# **SUPPLEMENTARY RESPONSE TO SUBMISSIONS**

Exhibited Phases 2 & 3 Lindfield  
Learning Village SSD 8114

**NSW DEPARTMENT OF EDUCATION**

26 August 2020

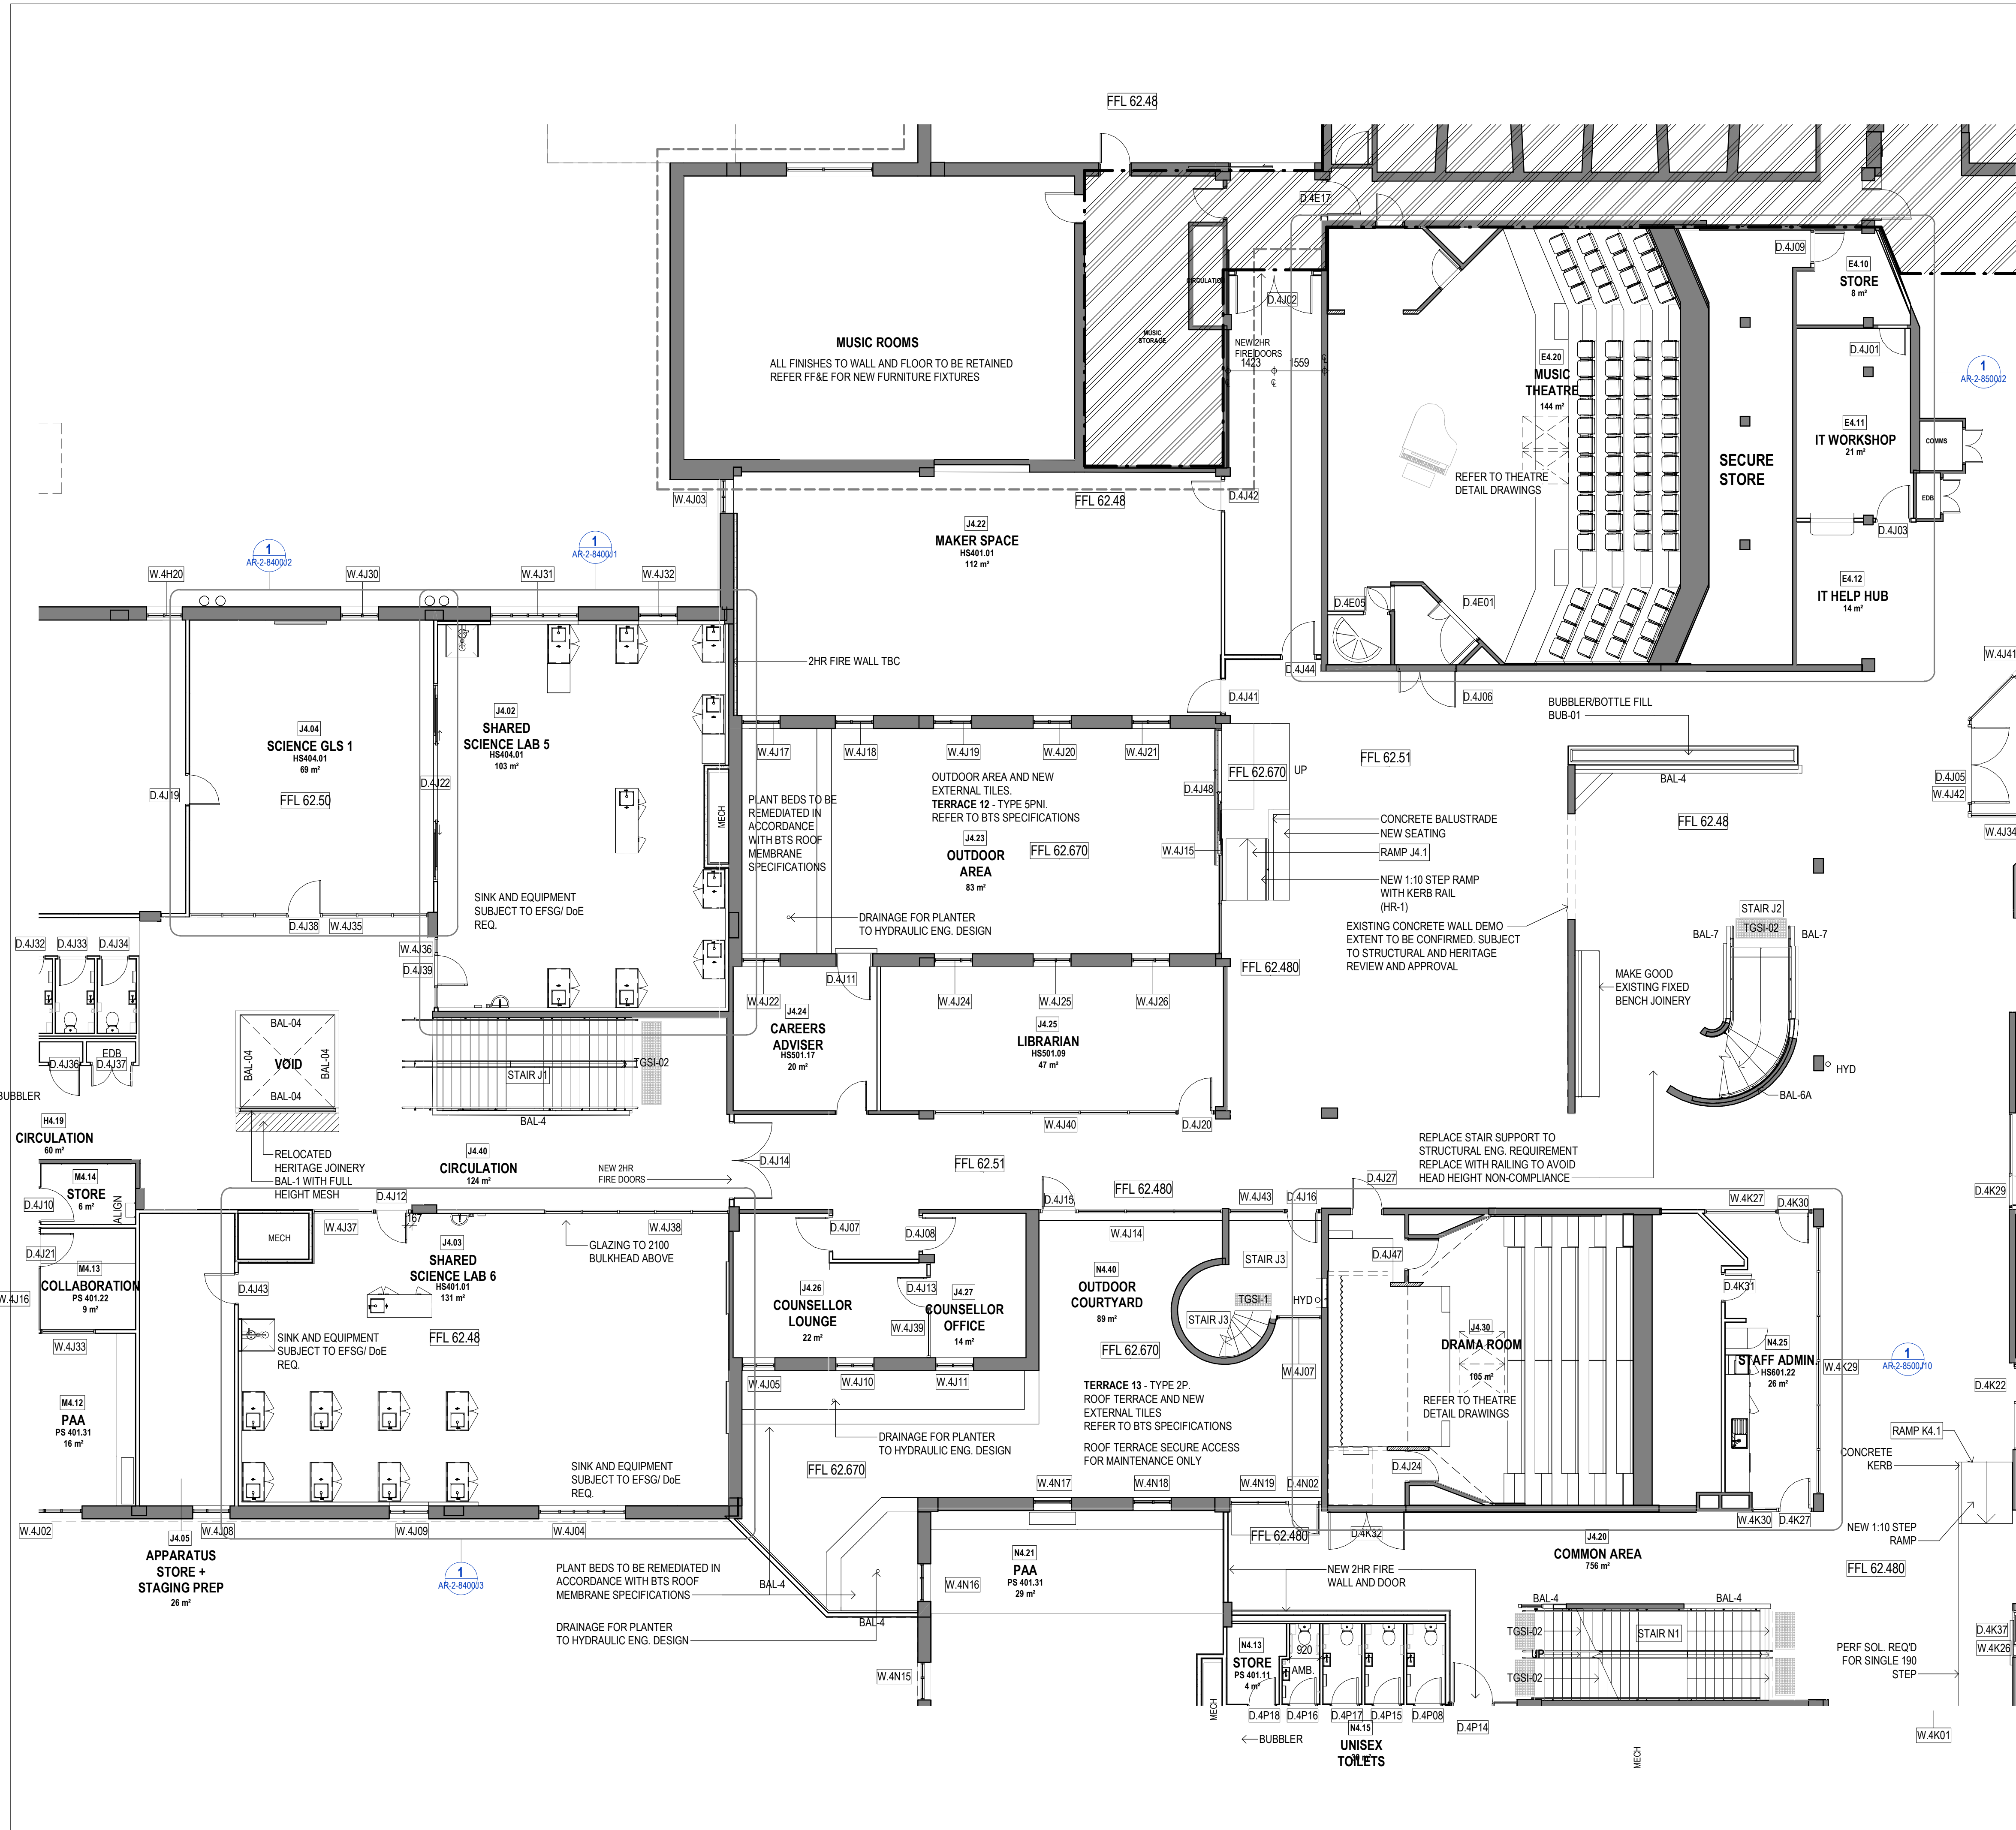
<b>Department of Planning and Environment</b>			
<b>C1</b>	<b>Further Detailed Plans and Information</b>		
C1	The RtS must provide detailed design plans of the demolition of the concrete wall adjacent to the spiral stair as also identified in Ku-ring-gai Council's (Council) submission.	Demolition drawings of the wall section adjacent to the spiral stair have been prepared by DesignInc and accompany this Supplementary RtS.	Refer <b>Appendix A</b> – Demolition Drawings
C2	Cross sections and elevations of the amended loop road design must be provided as part of the RtS.	The Civil Plans include a Typical Cross Sections (C.228) and Elevated Road Structural Plan (C.300), which accompany the Supplementary RtS. These drawings demonstrate the typical road sections profiles used at different intervals and how it impacts the site.	Refer <b>Appendix C</b> – Civil Drawings
C3	The RtS must also include confirmation for the use of Charles Bean oval; whether it is remaining as originally proposed or if an alternate option is to be utilised to facilitate access by additional students.	The school currently has use of Charles Bean oval from 9am - 4pm on school days. This access is critical to the school's ability to deliver the Sport and Physical Education curriculum. Phases 2 and 3 of the school intend to maintain this exclusive use of Charles Bean Oval given there is no alternate facility on site. SINSW and Council are currently in discussions regarding an extension of the lease to continue use of the oval.	N/A

ELEVATED ROAD STRUCTURAL PLAN
SCALE 1 : 150

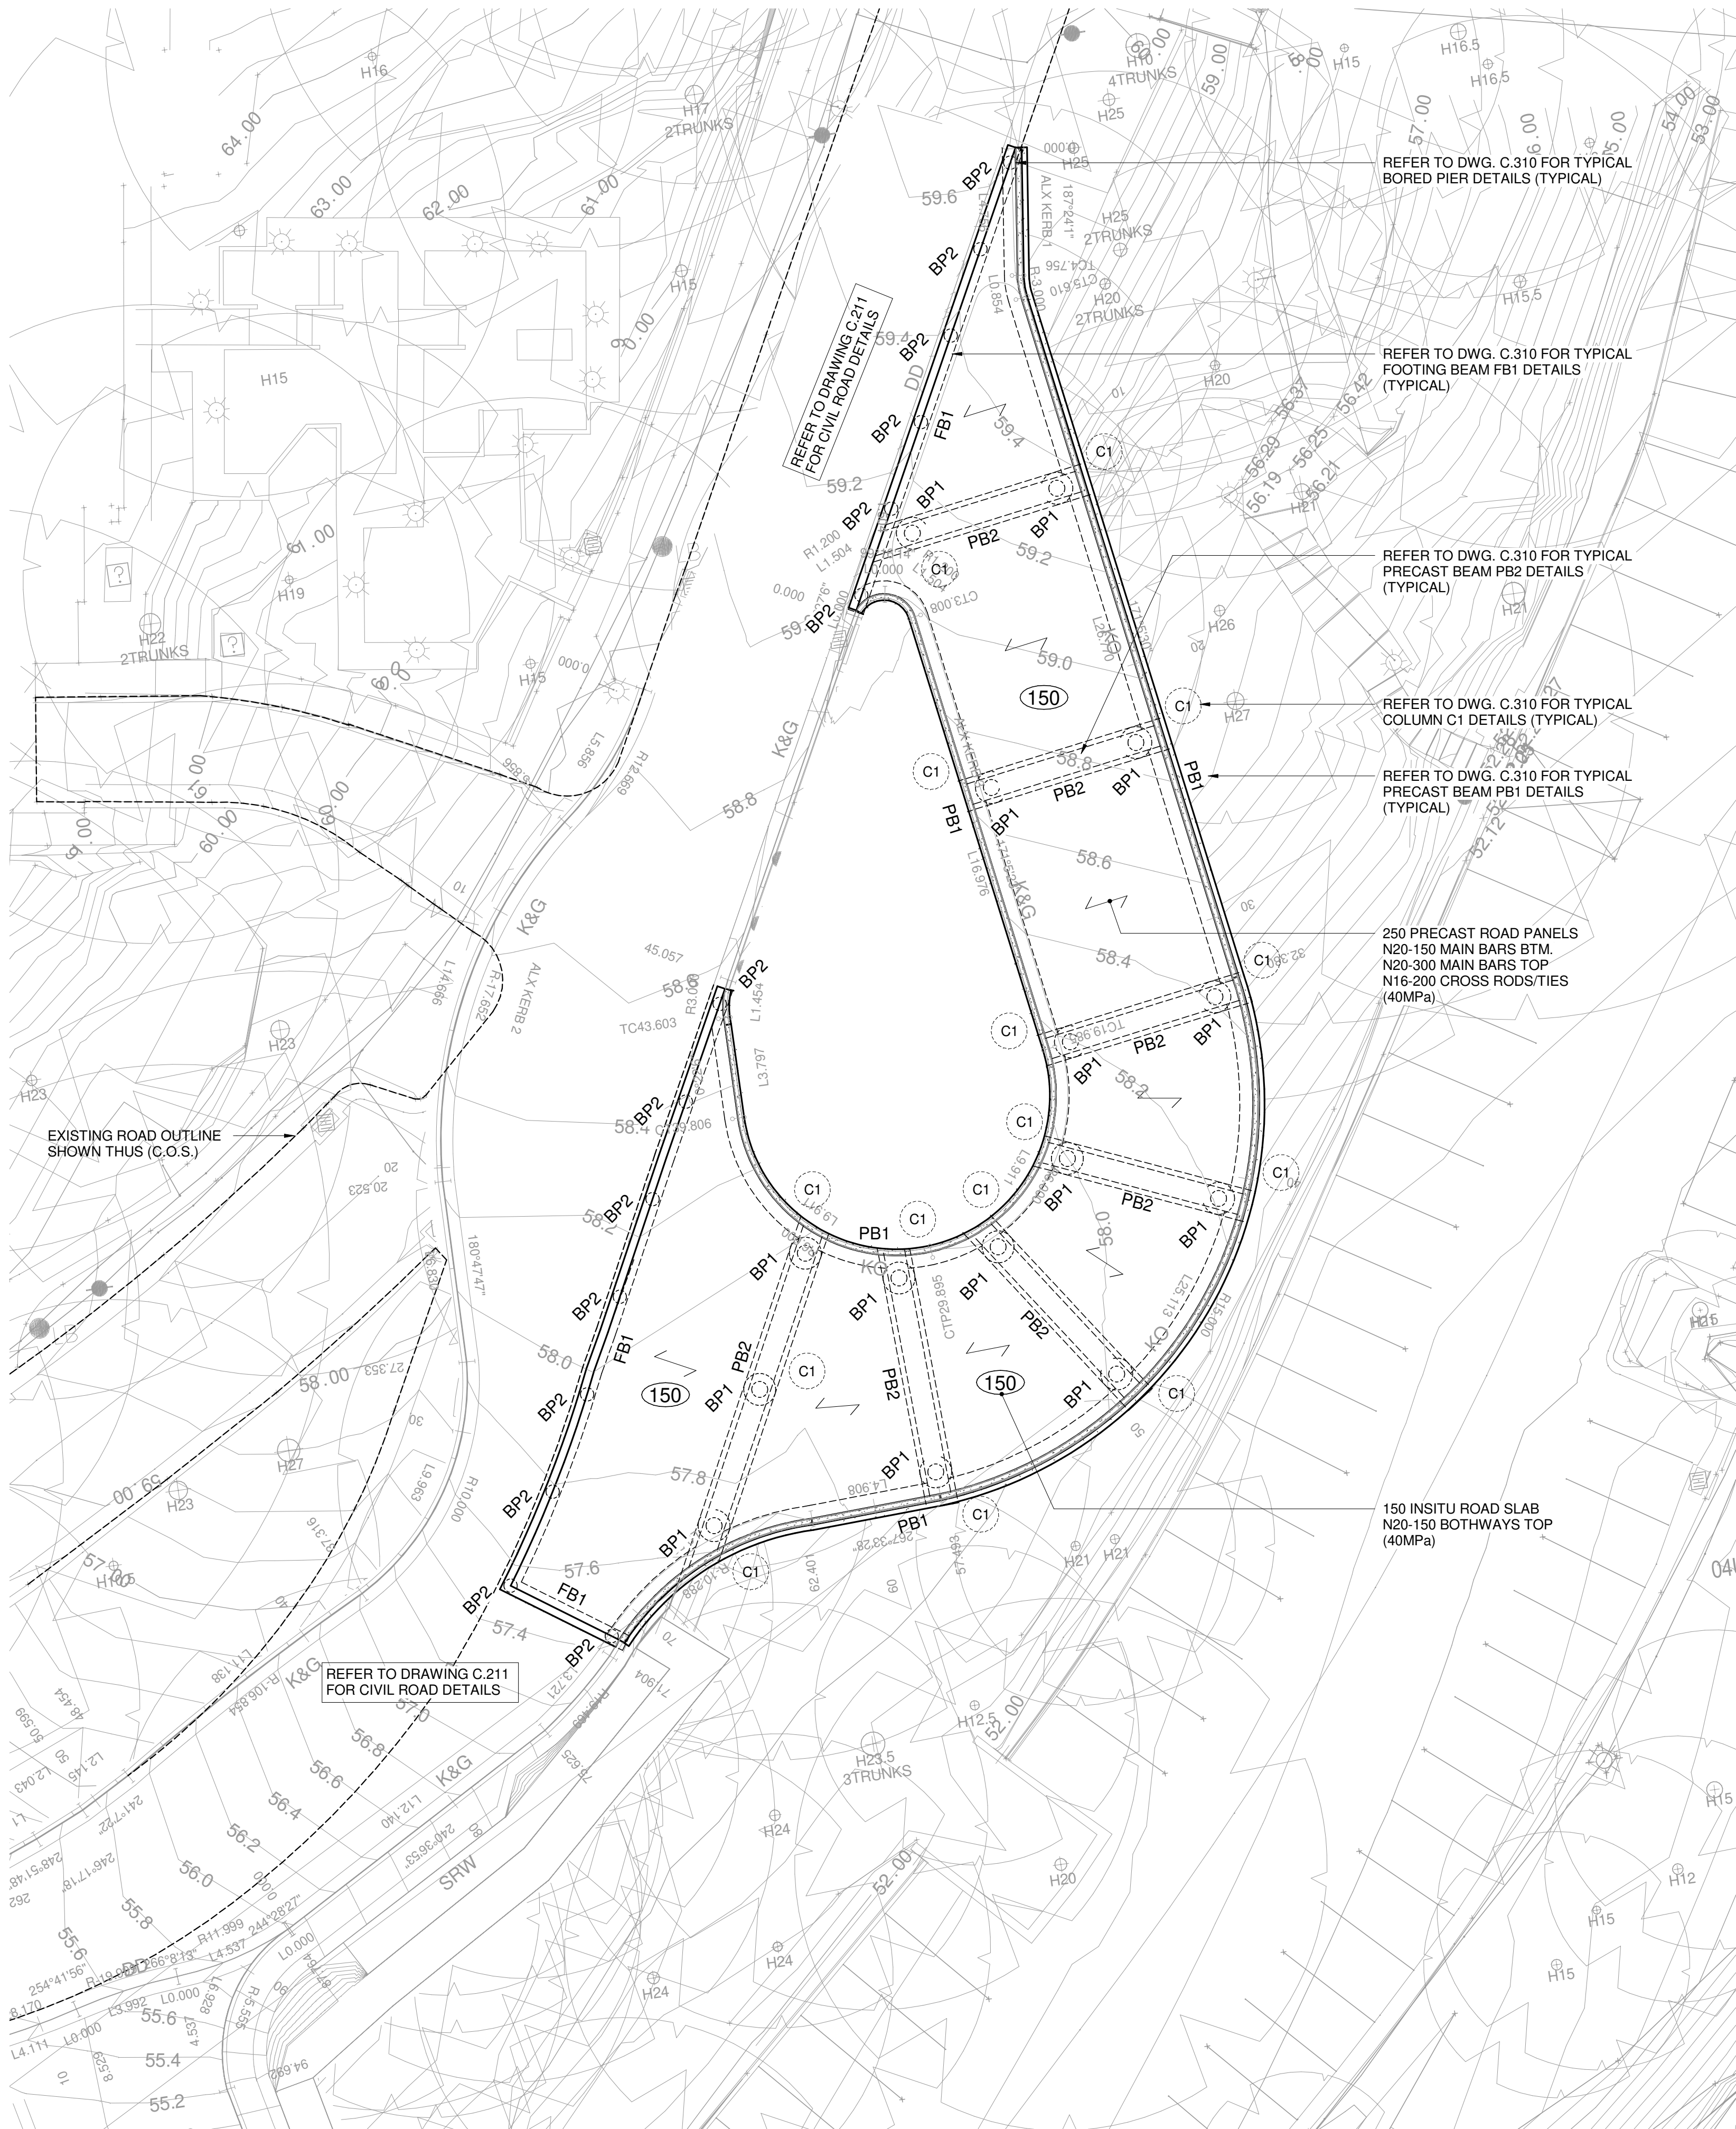
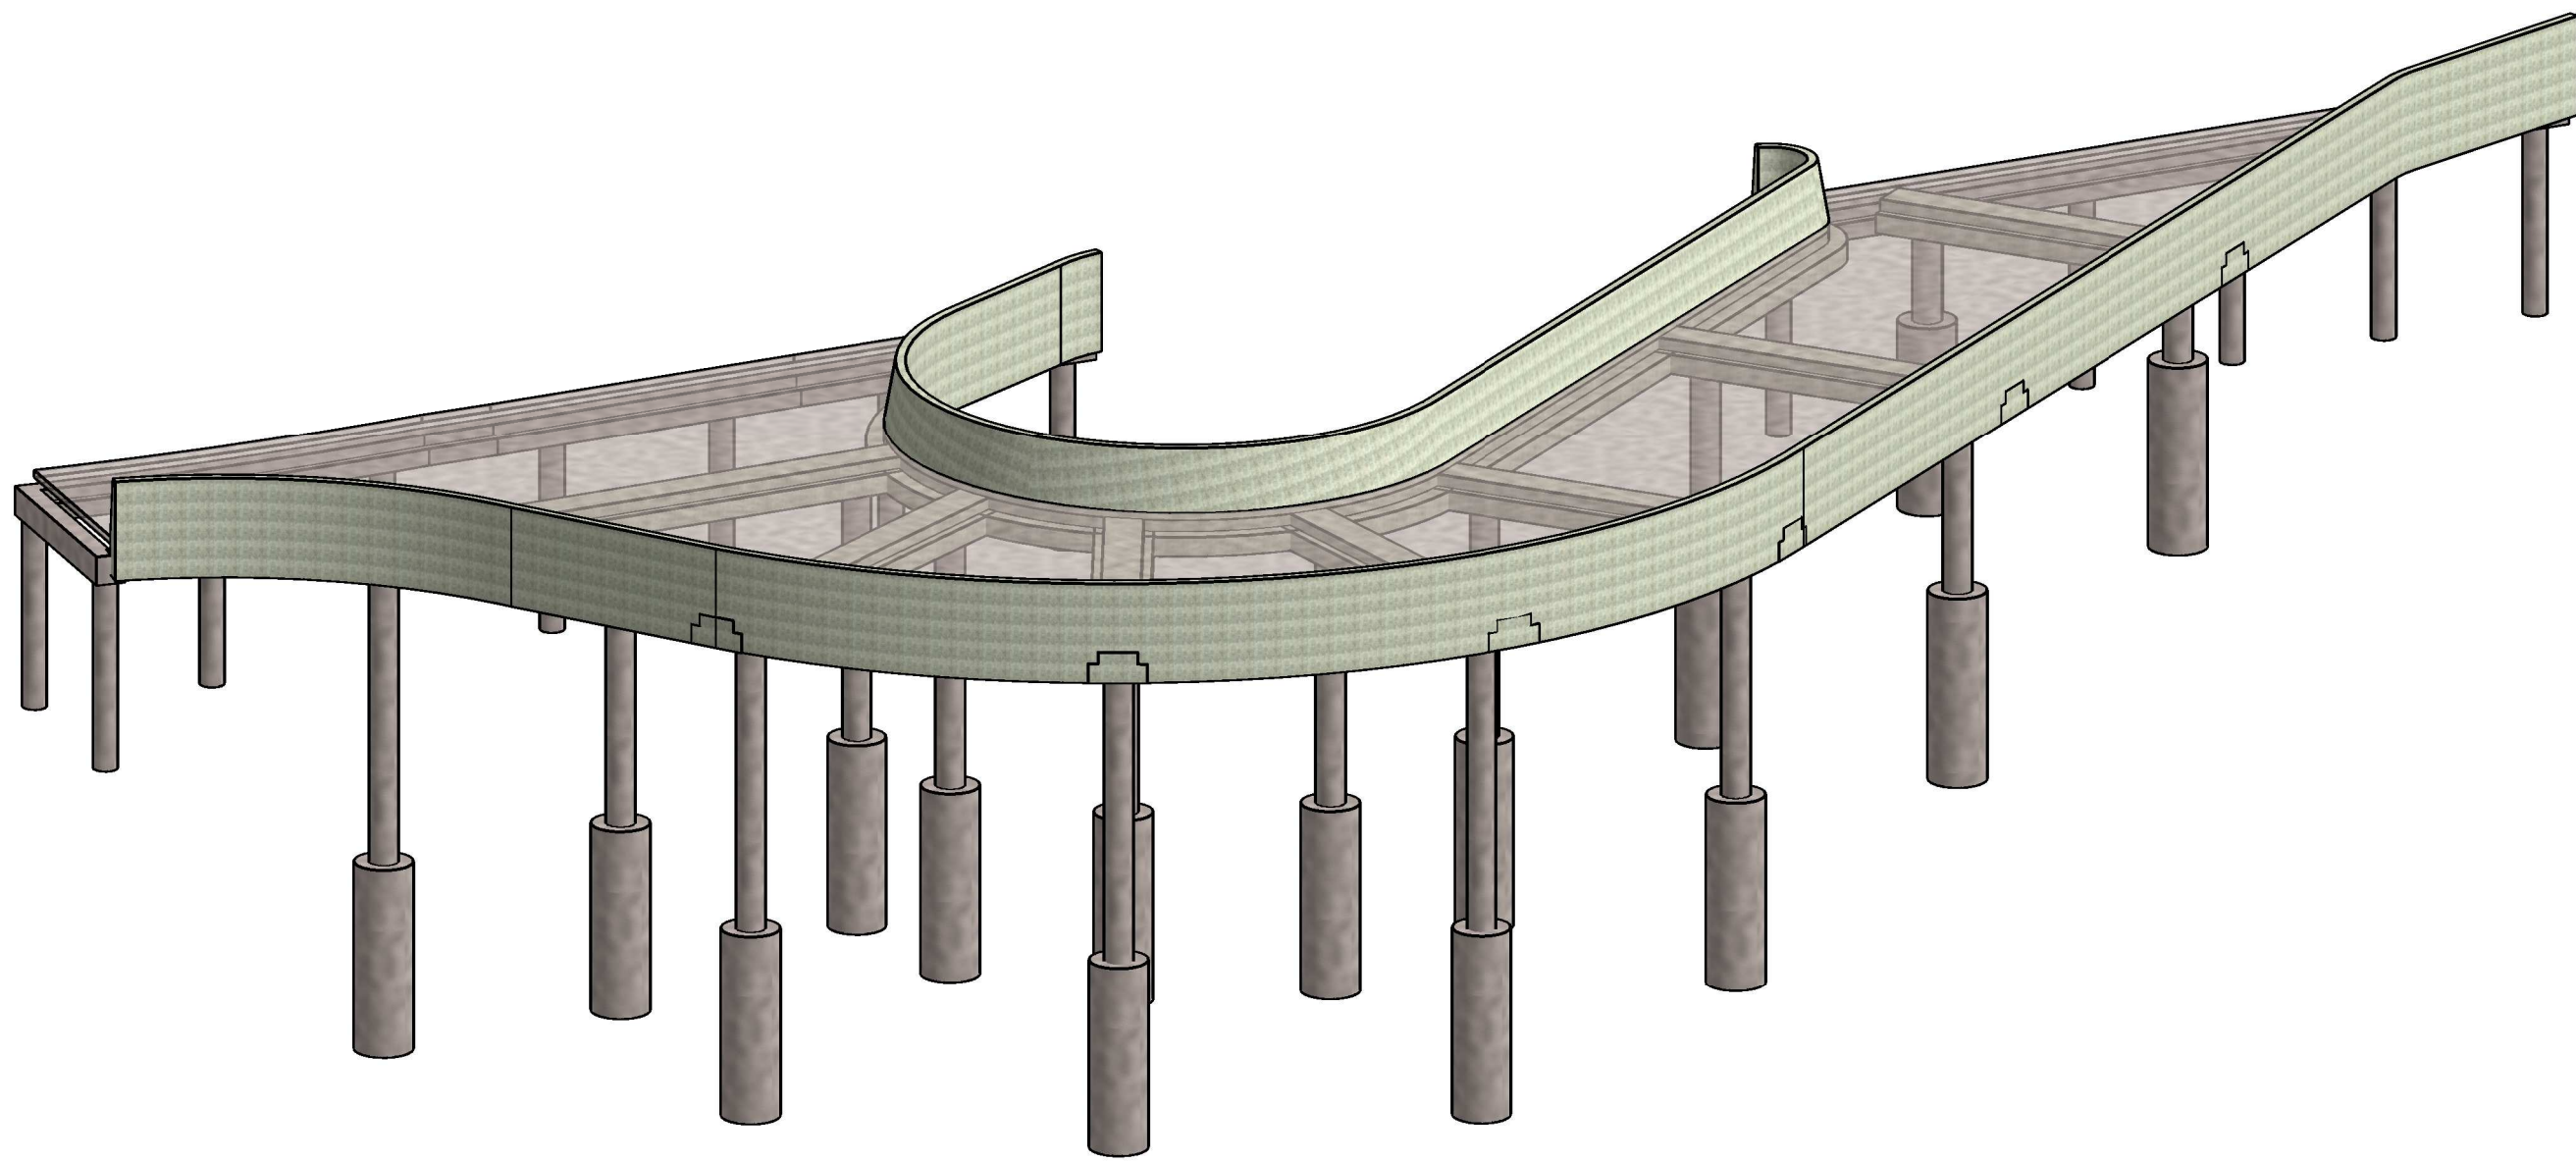
<b>B.</b>	<b>Road and Safety</b>		
B1	<p>The RtS must provide an updated road safety audit report and construction management plan that includes consideration of the potential operational conflicts for the following areas (but not limited to):</p> <ul style="list-style-type: none"> <li>- the operation of the existing Phase 1 parking and pick-up and drop-off facilities during the construction of the loop road and other construction activities.</li> <li>- potential safety risks and hazards caused by the active play space linemarking on the area to be used for parent pick-up and drop-off at the end of the loop road (as detailed in landscape plan LA-2-0006).</li> </ul>	<p>A road safety audit was completed on the concept design. The issues raised in the audit were noted and mitigations incorporated into the ongoing detailed design process. Management mitigations for the active play space and drop off pick (DOPU) dual use have been developed to mitigate these hazards. This audit report is included in the revised Traffic Response.</p>	Refer <b>Appendix E</b> - Transport Response.
